## MEMORANDUM

**Subject:** Application ID: 2015-027

**Date:** 3/23/2015

**Comments Submitted by: Bruce Hyman/Parks on 3/10/2015**

**DOWNTOWN RACK - SPECIFICATIONS AND SPACE USE**  
N.T.S.

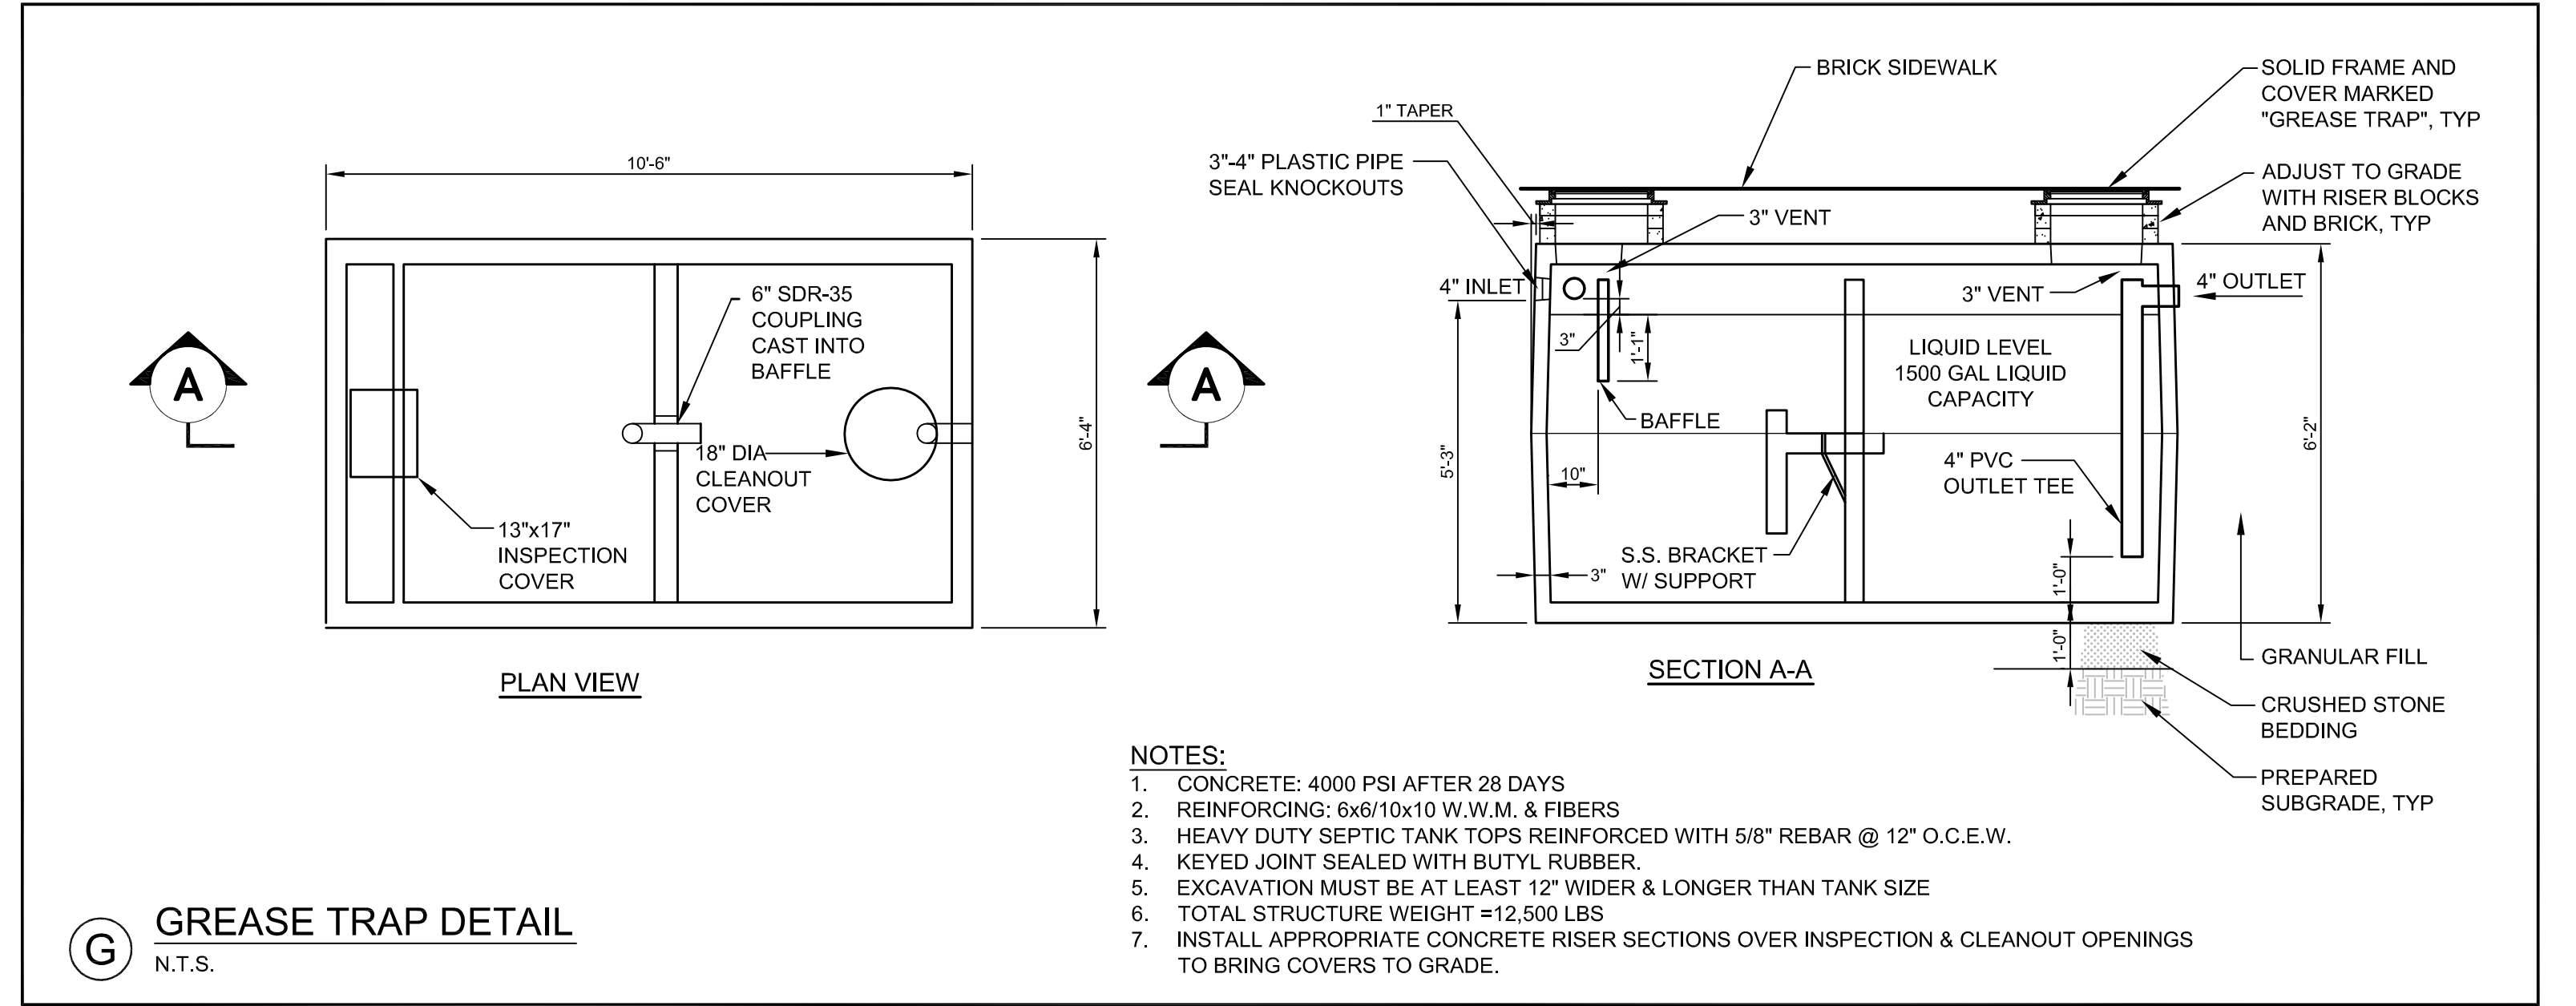
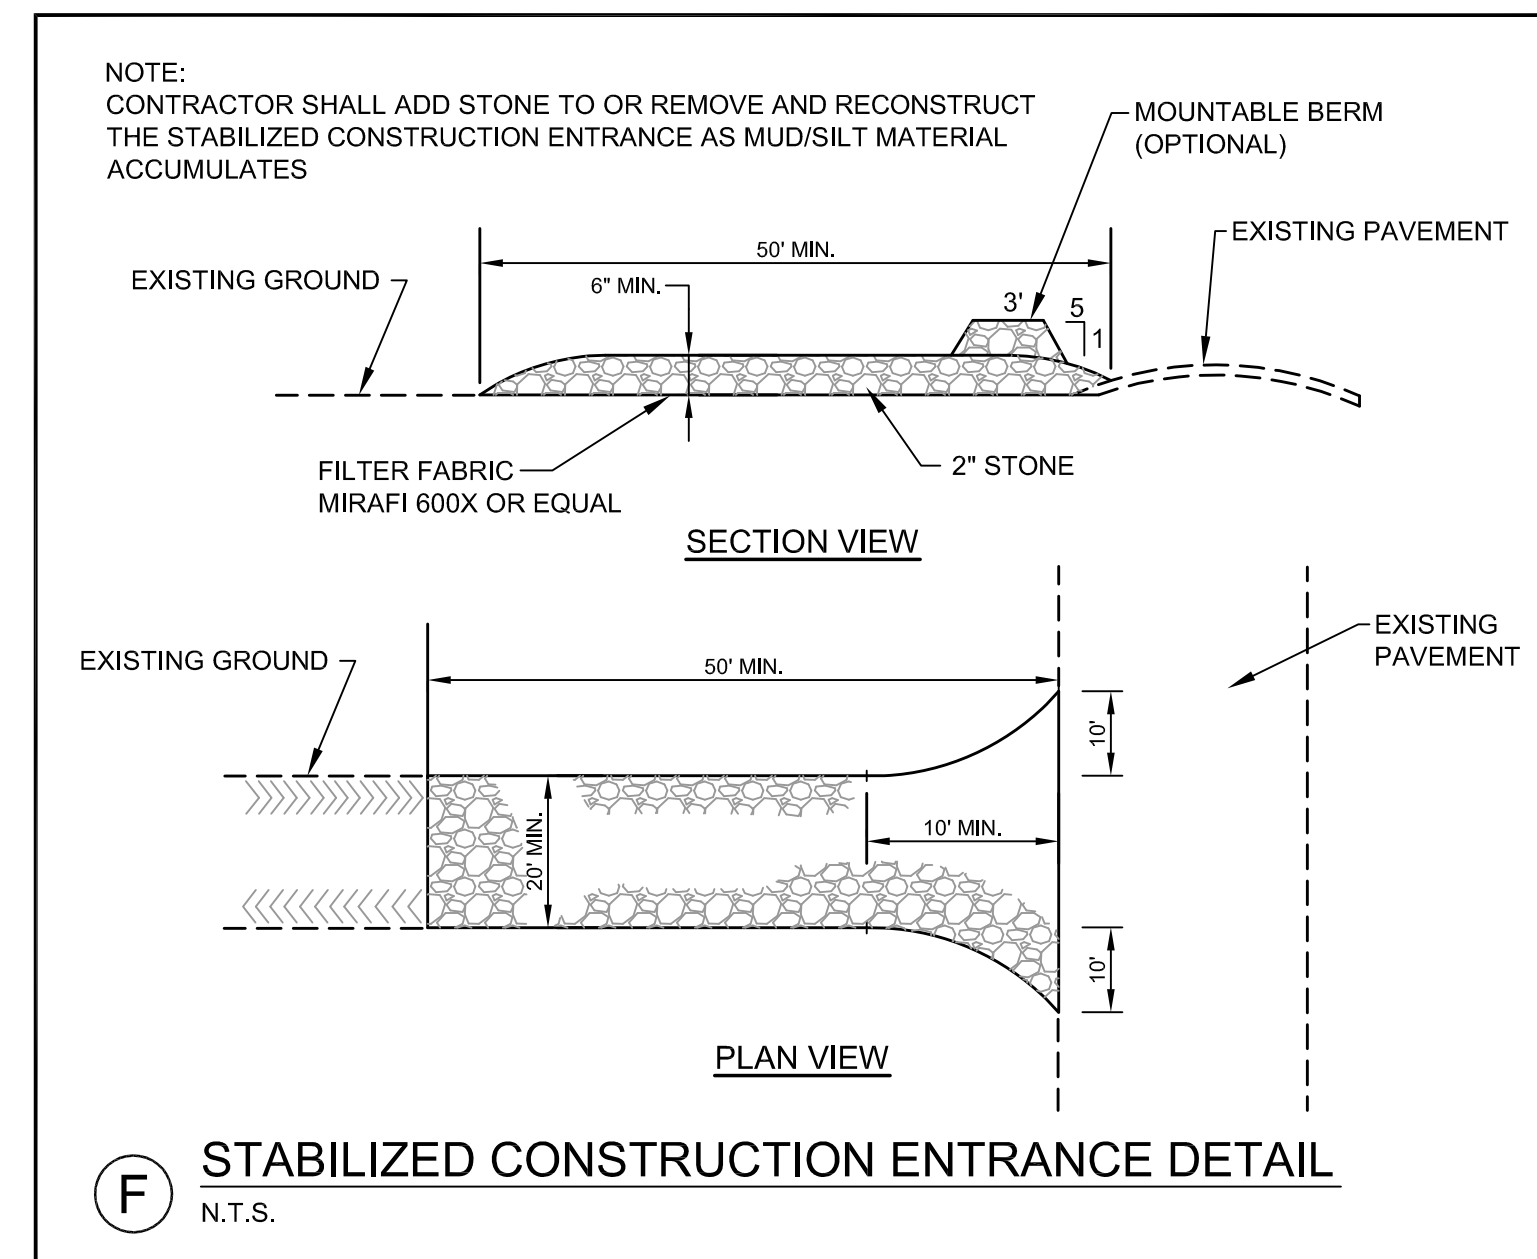
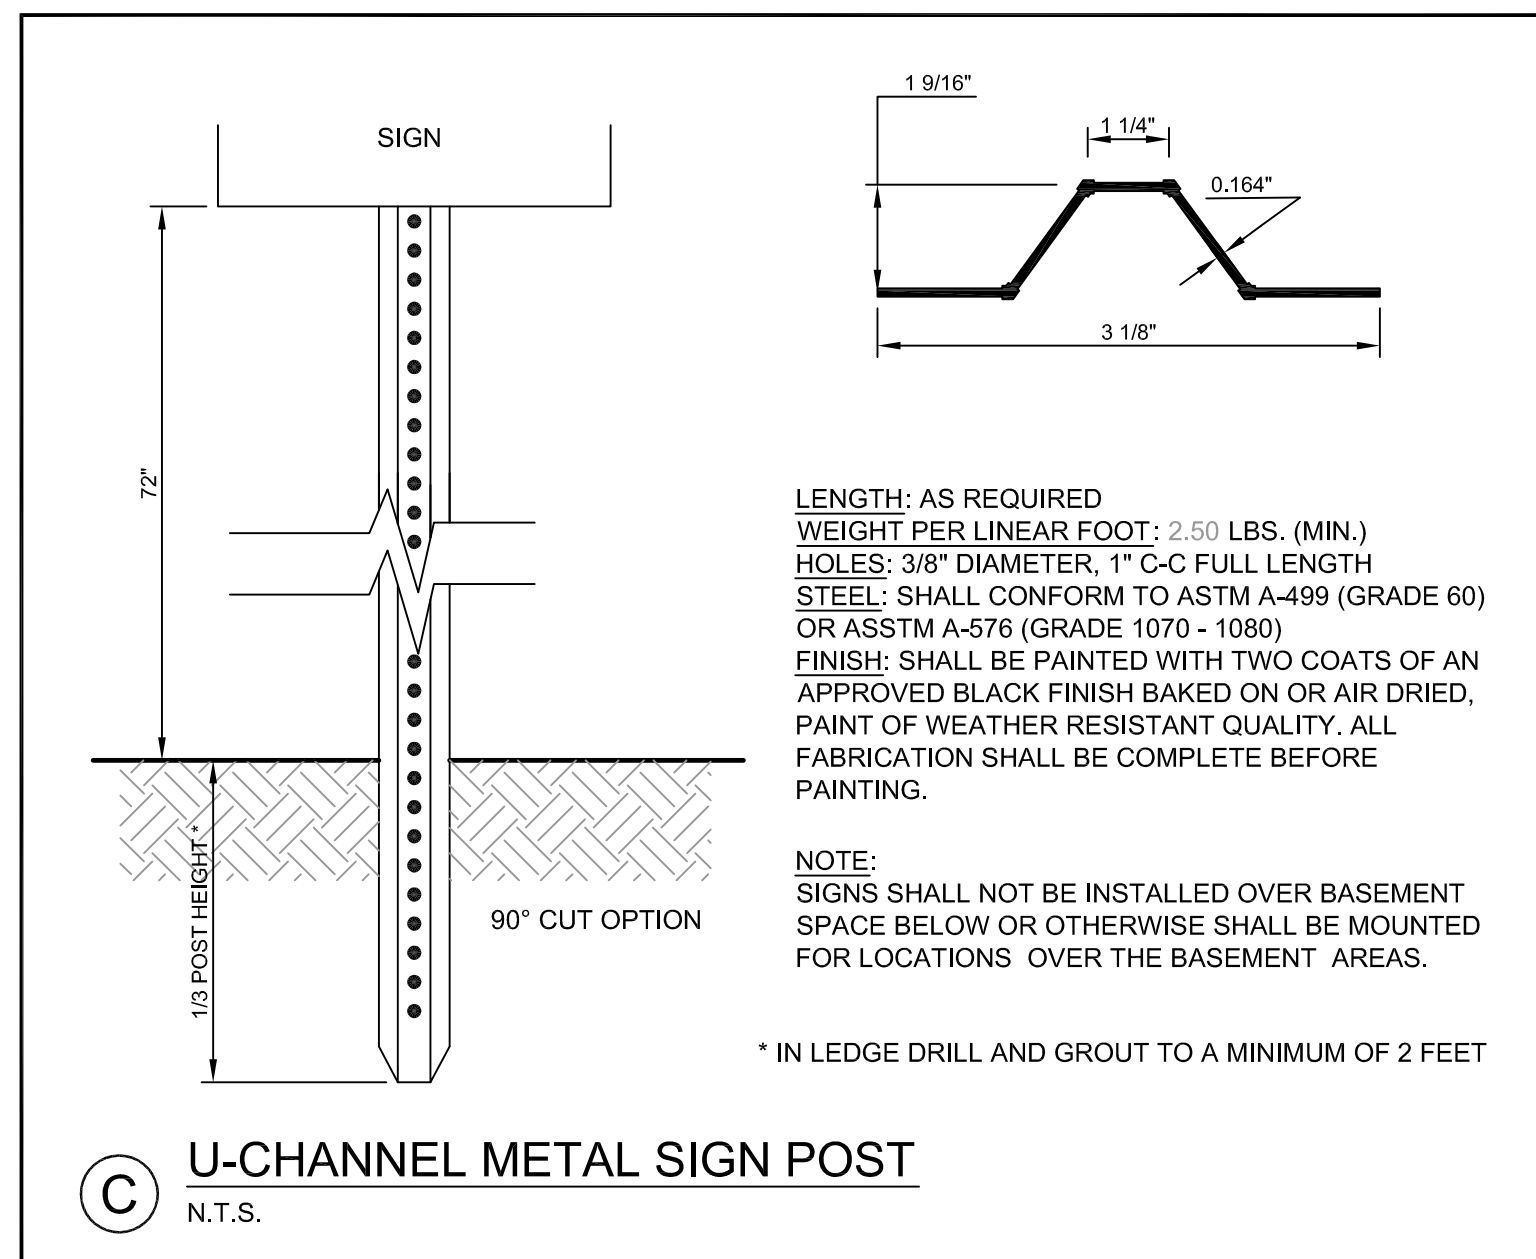
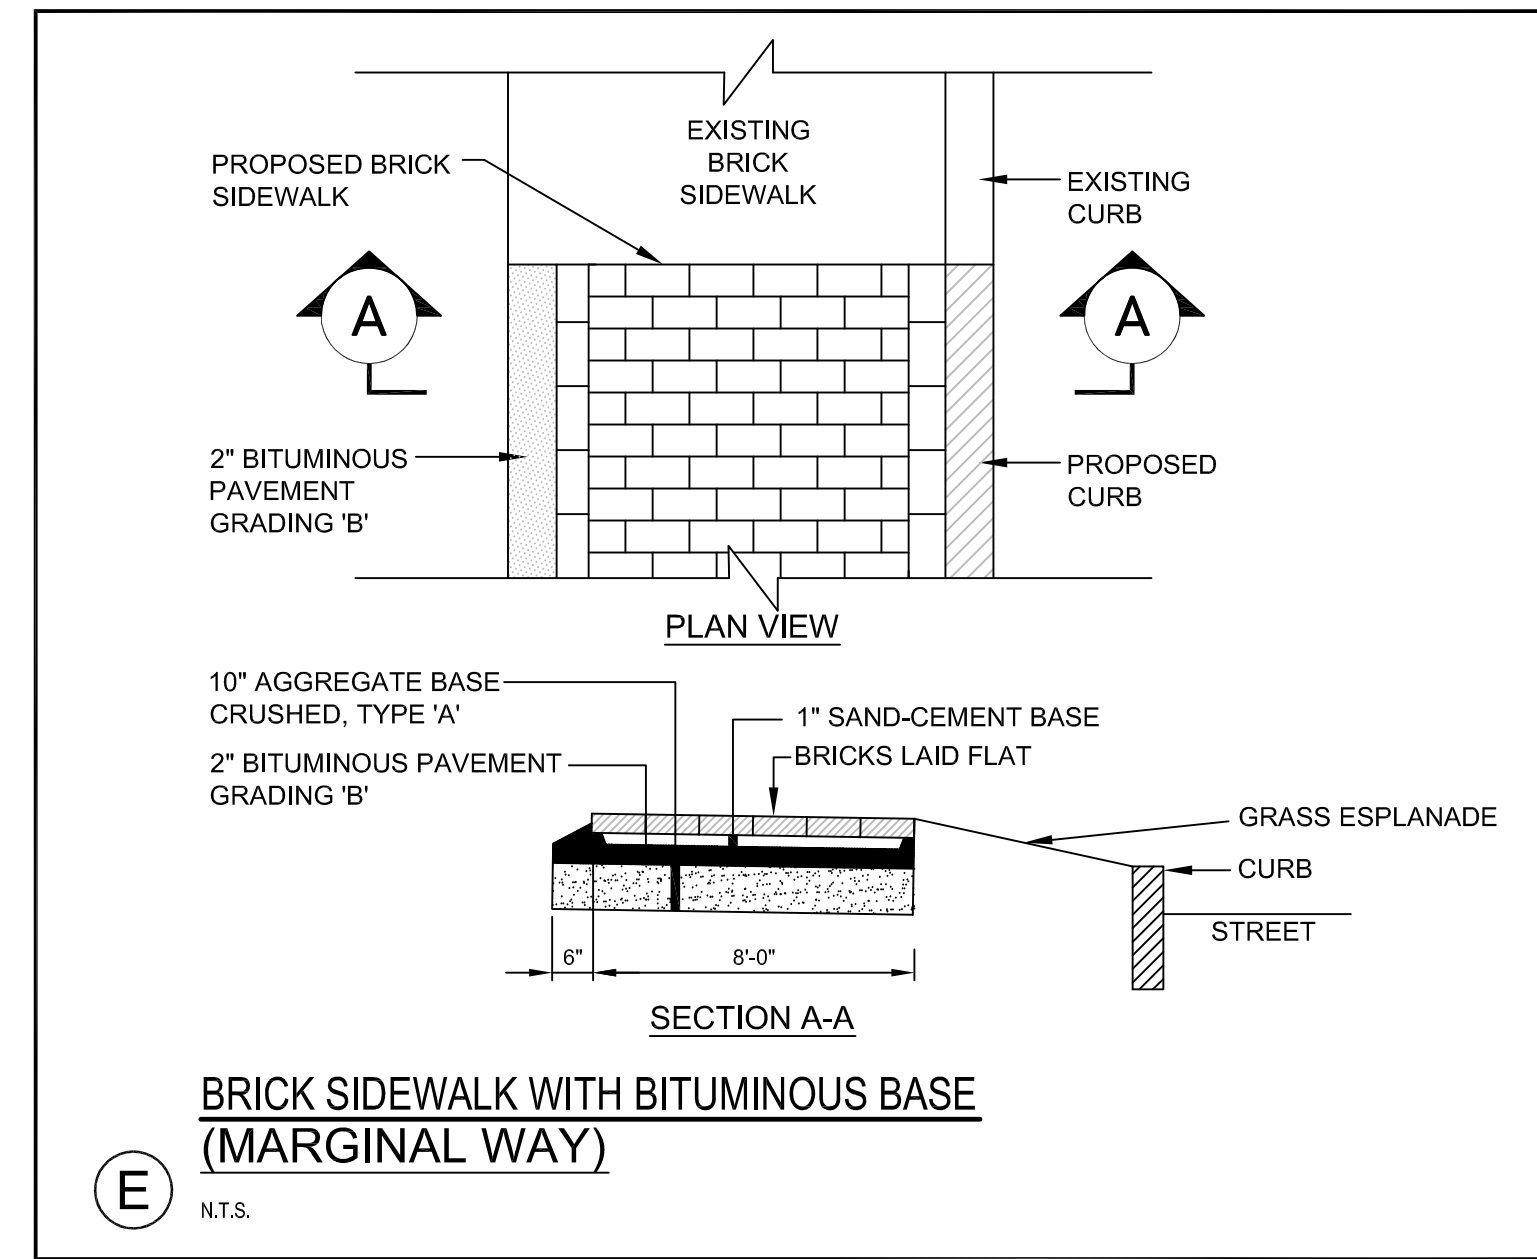
\*\* The bike parking concrete pads should be a minimum of 8' in length and 6' in width (9'x6' better) to ensure their functionality - it's a little hard to scale accurately from the 11x17 plans - they may be that already.
